From: Nicola Swann [REDACTED]
Sent: 06 April 2022 11:07
To: Planning.Responses <Planning.Responses@arun.gov.uk>
Subject: Pagham responses

P/22/22/PL – Land West of Hook Lane Pagham. Variation of Condition 1 imposed under P/132/20/RES relating to approved plans.

Drawing Title
Plans & Elevations Type
Bungalow - Timber
Weatherboard
Plots 84 Handed 64

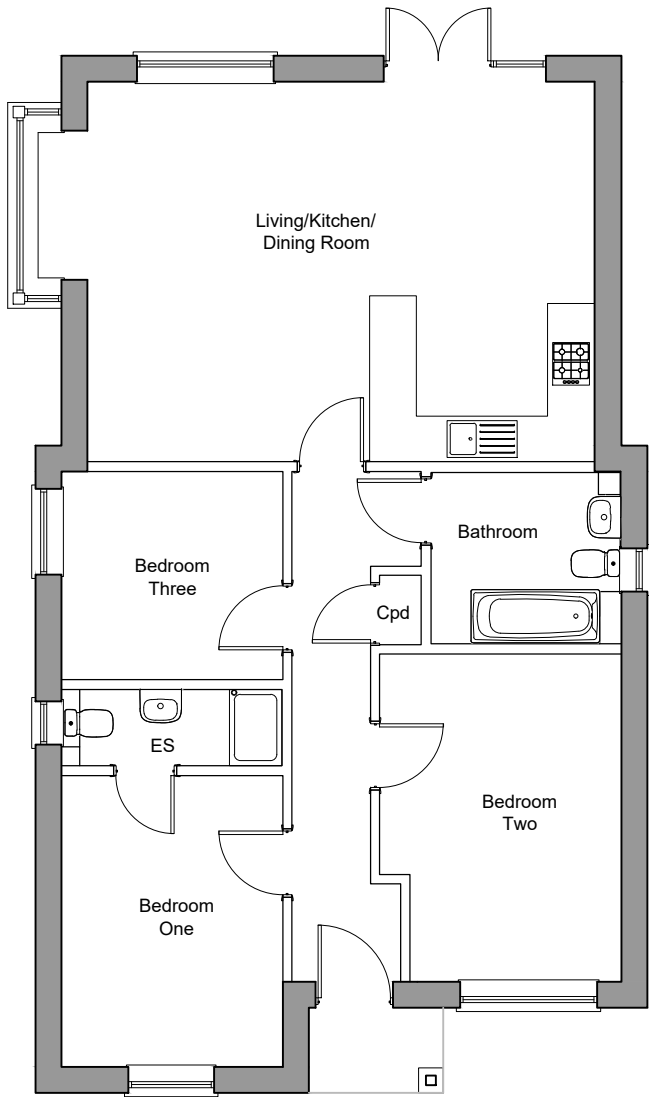
The black weatherboarding shown on the Hook Lane entrance street scene is not attractive or in keeping. The housing proposed here doesn't blend with the other proposed housing and doesn't give a farmyard feel.
